Attachment 1 Department's Comments

Traffic and access

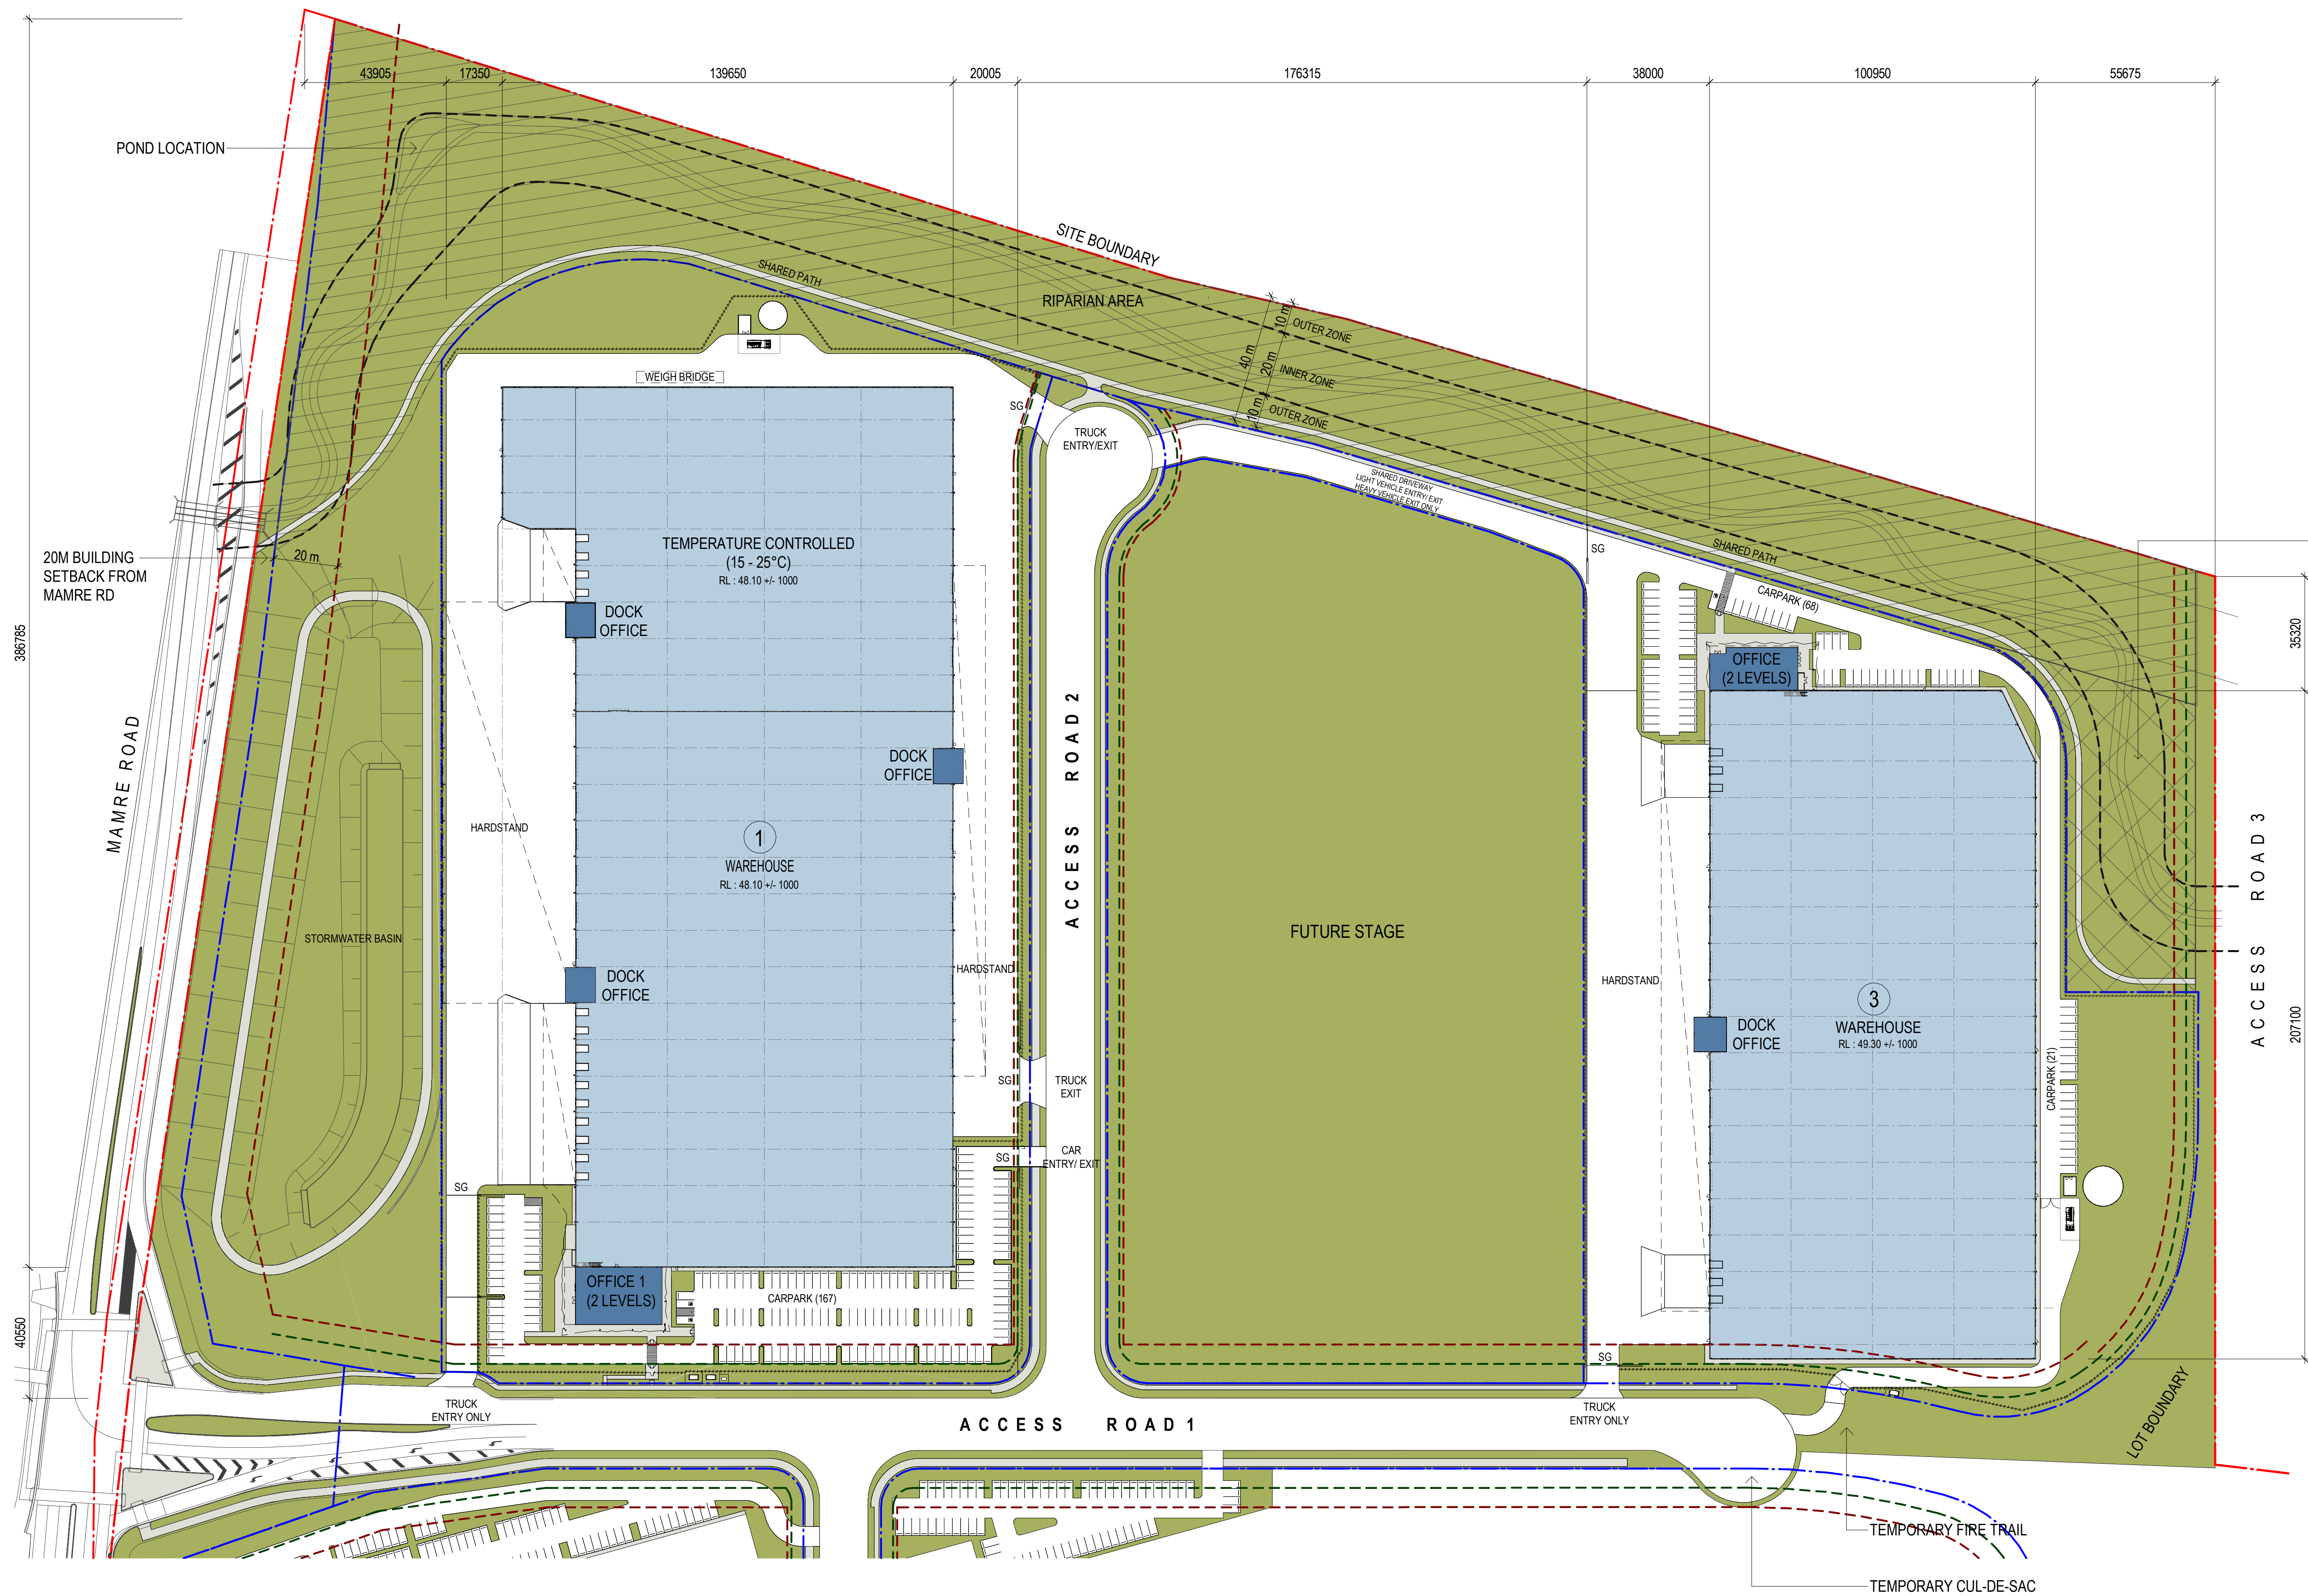
1. Please provide evidence of consultation with TfNSW regarding the proposed deceleration lane on Access Road 1 leading to Warehouse 1 inbound driveway.

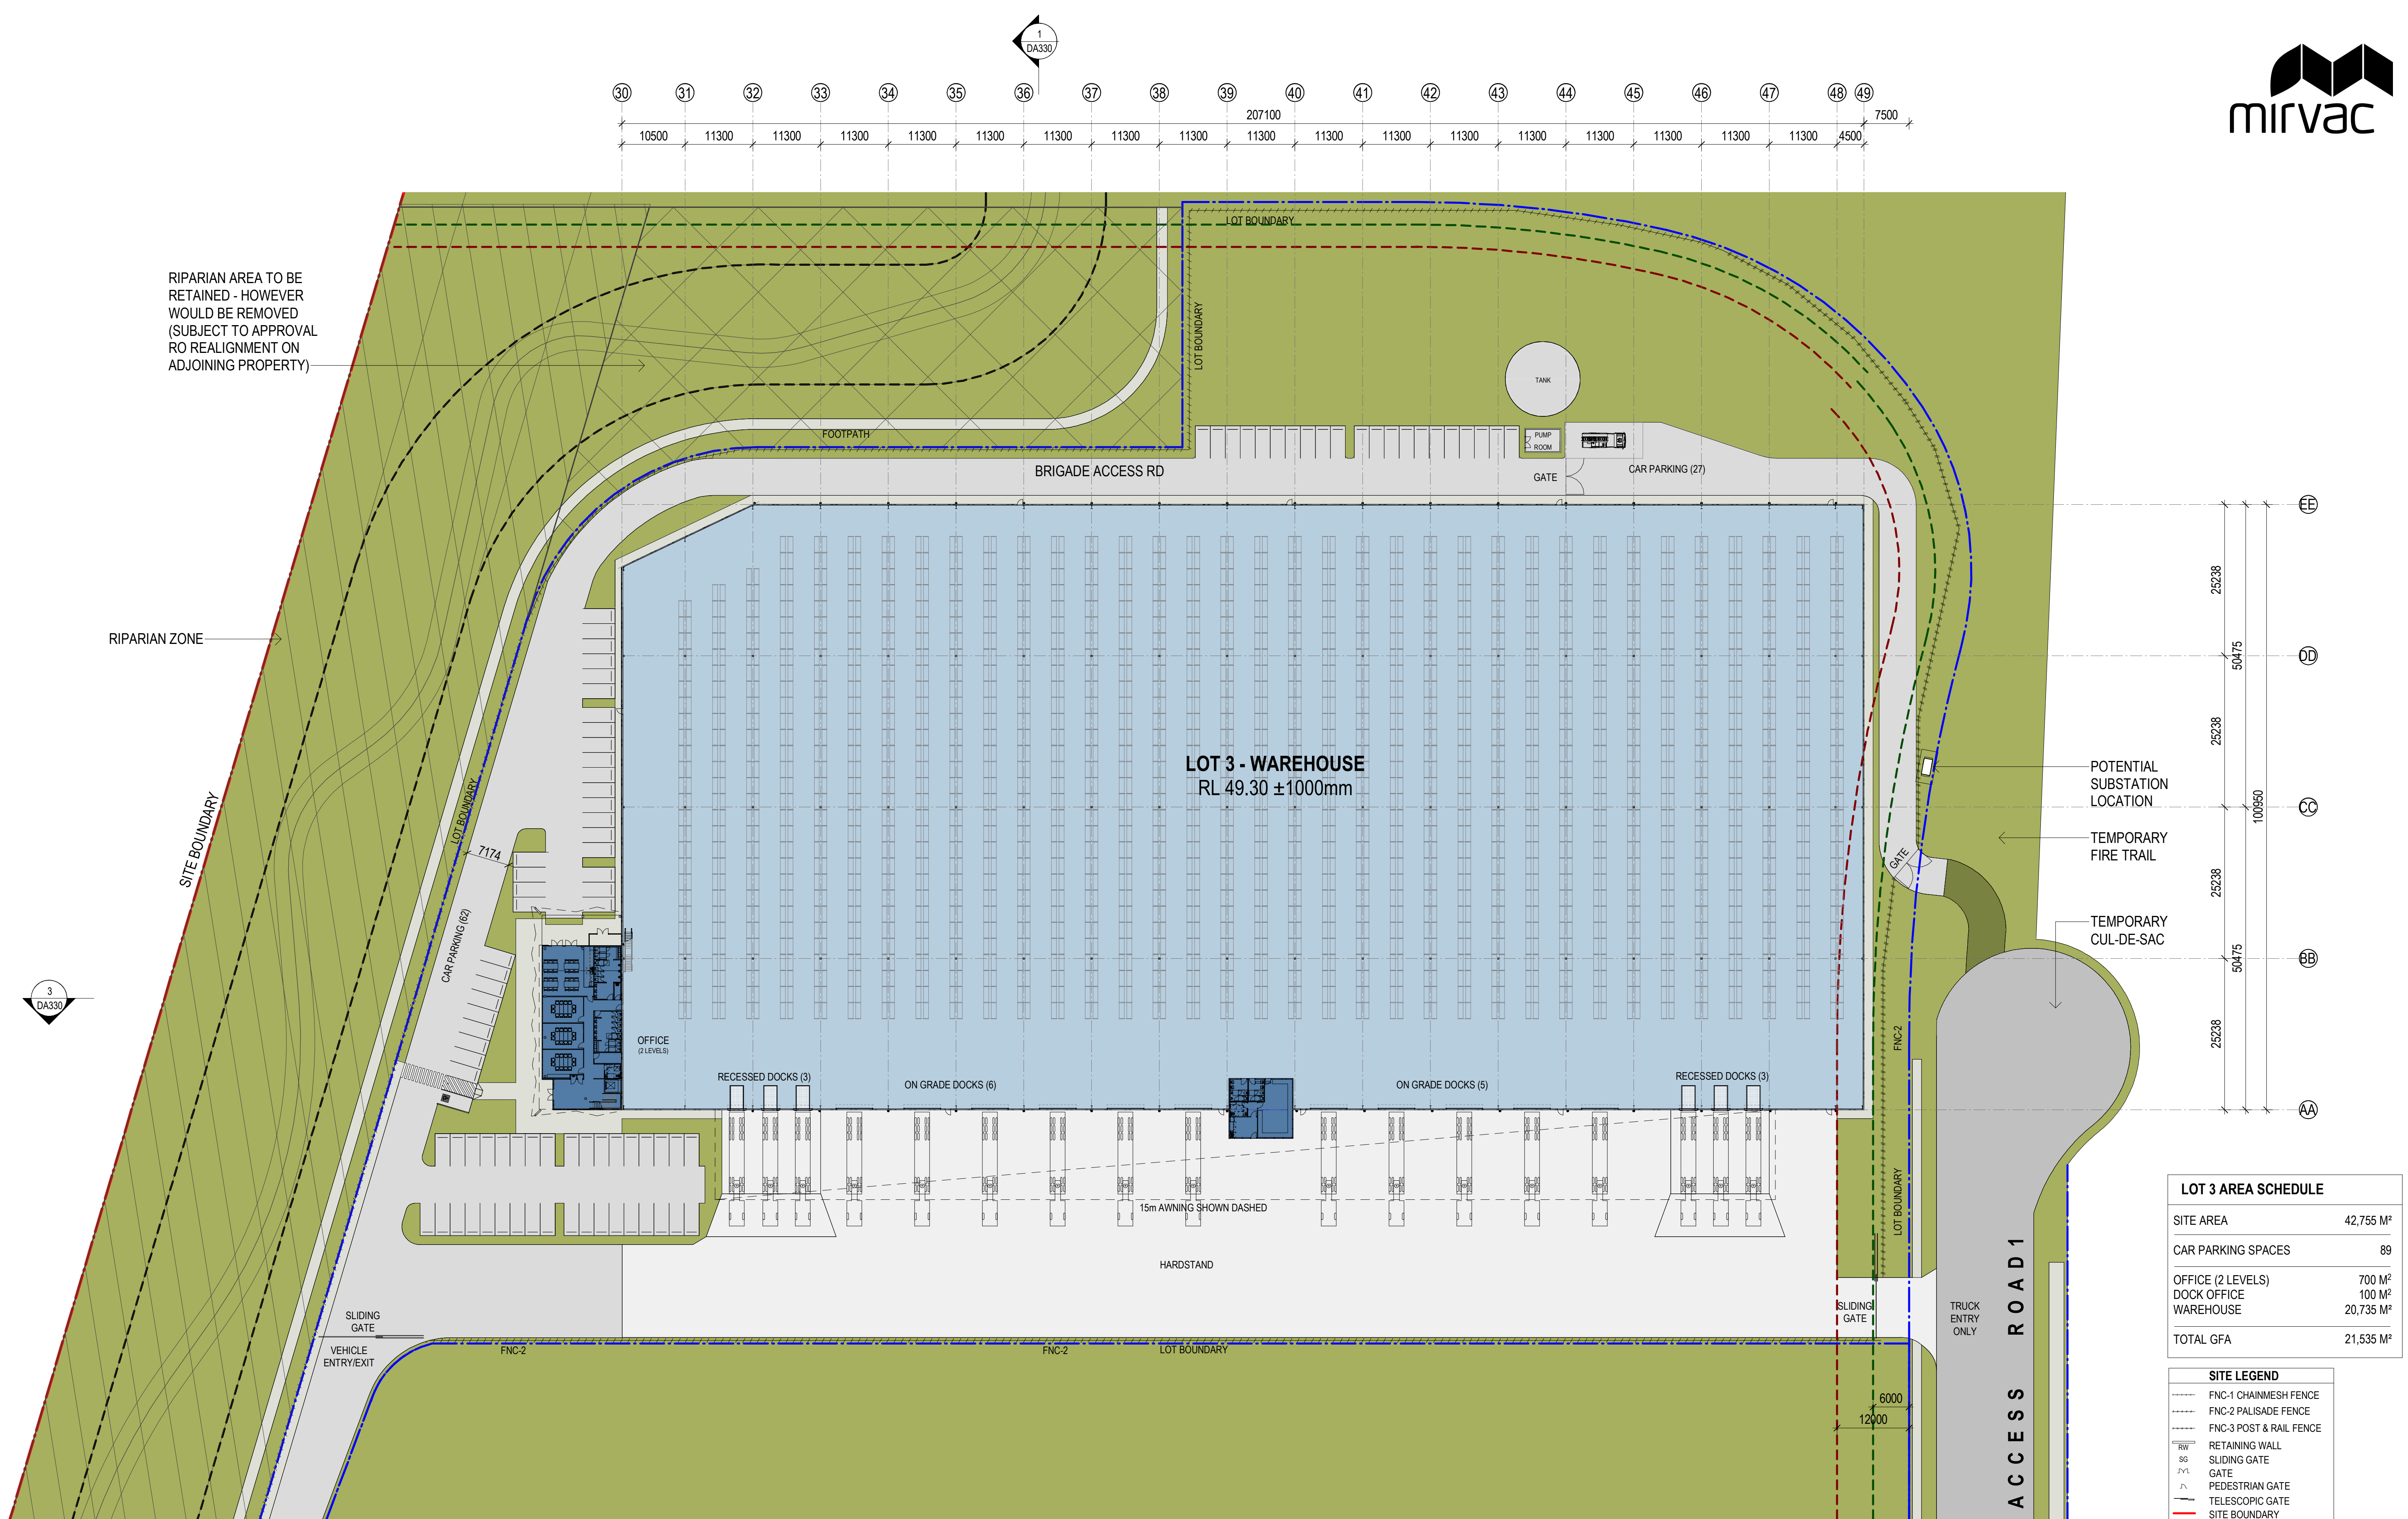
2. The Department notes Warehouse 3 would have a shared heavy and light vehicle driveway on Access Road 2. Provide details of traffic management measures to be implemented to ensure safe movements in Lot 3. The Applicant should consult with Council regarding the driveway in question and make any amendments where necessary to address any concerns raised by Council.

3. The Department concurs with Penrith City Council that Warehouse 3 includes a driveway close to Access Roads 1 and 3 intersection, which has the potential to impact on safe operation of Access Roads 1 and 3. Further, the proposed parking spaces to the east of Warehouse 3 are isolated from the office. Employees need to walk on the shared driveway to the office which gives rise to safety concerns. Please consider relocating the driveway in question away from the roundabout in consultation with Council and consolidate all parking spaces in one place close to the office.
